EARLY GRADING AND EROSION CONTROL PLANS SPRINGS AT WATERVIEW

EL PASO COUNTY, STATE OF COLORADO

PCD NO. SP-16-005

Sediment Basin (SB)

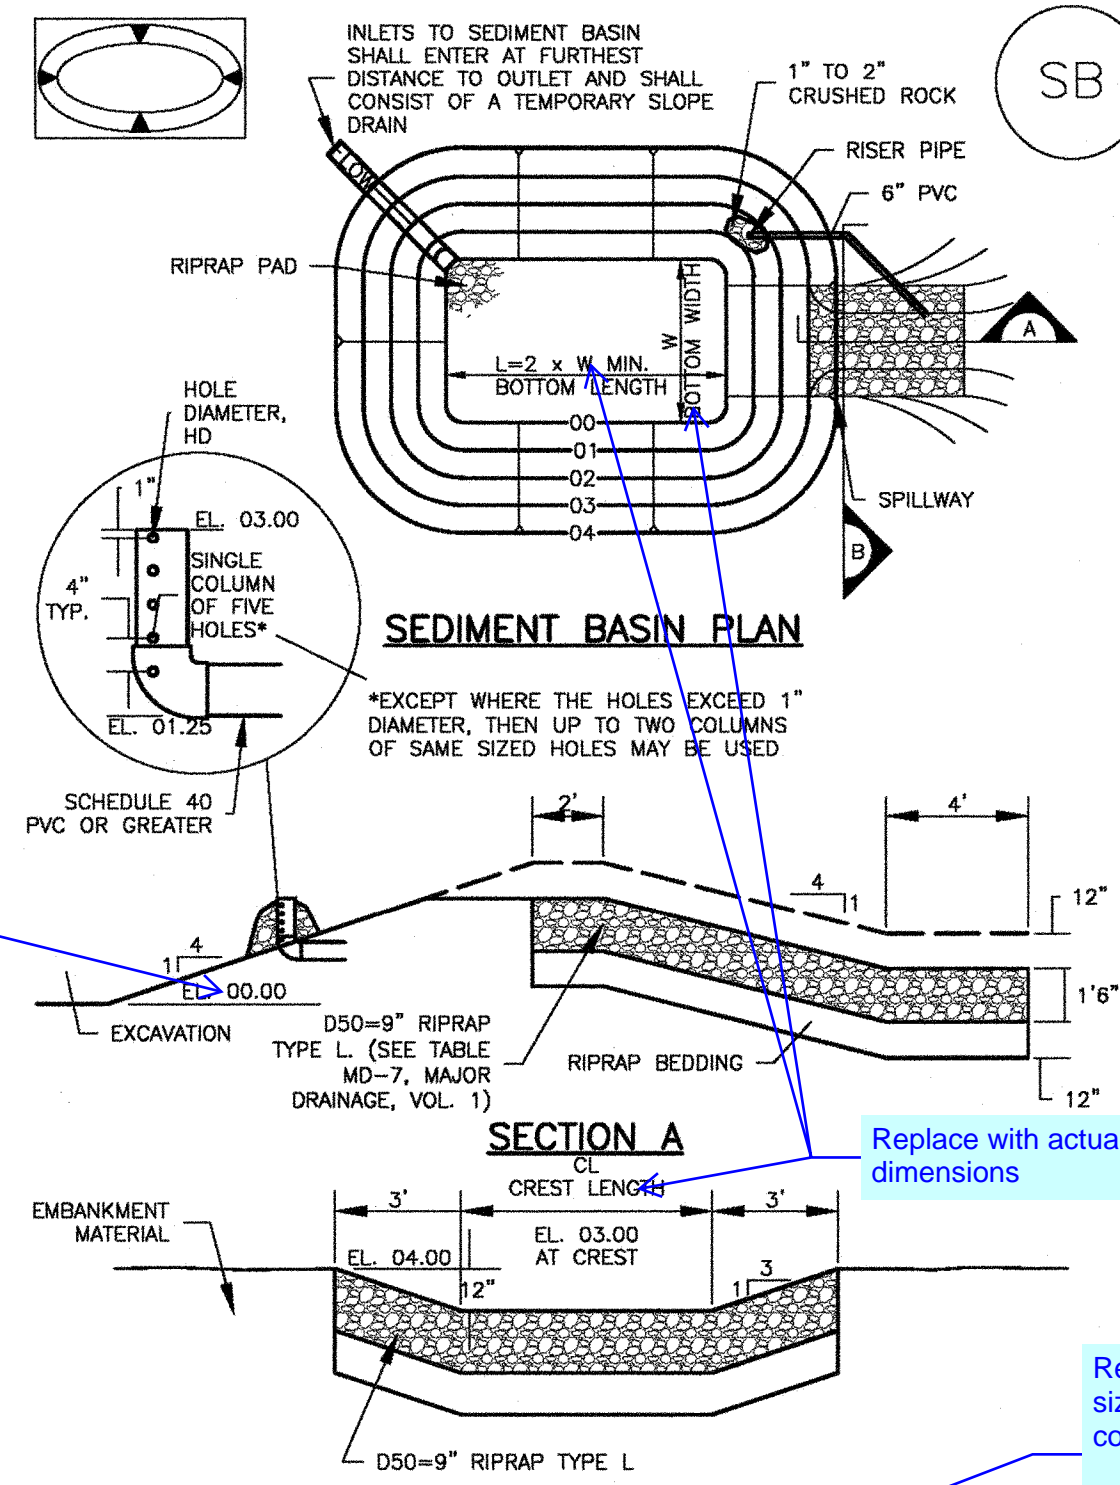
Unresolved. Identify on the plan view or
the detail the required orifice hole
diameter for the riser pipe. Additionally,
show the riser pipe and outfall layout on
the plan view
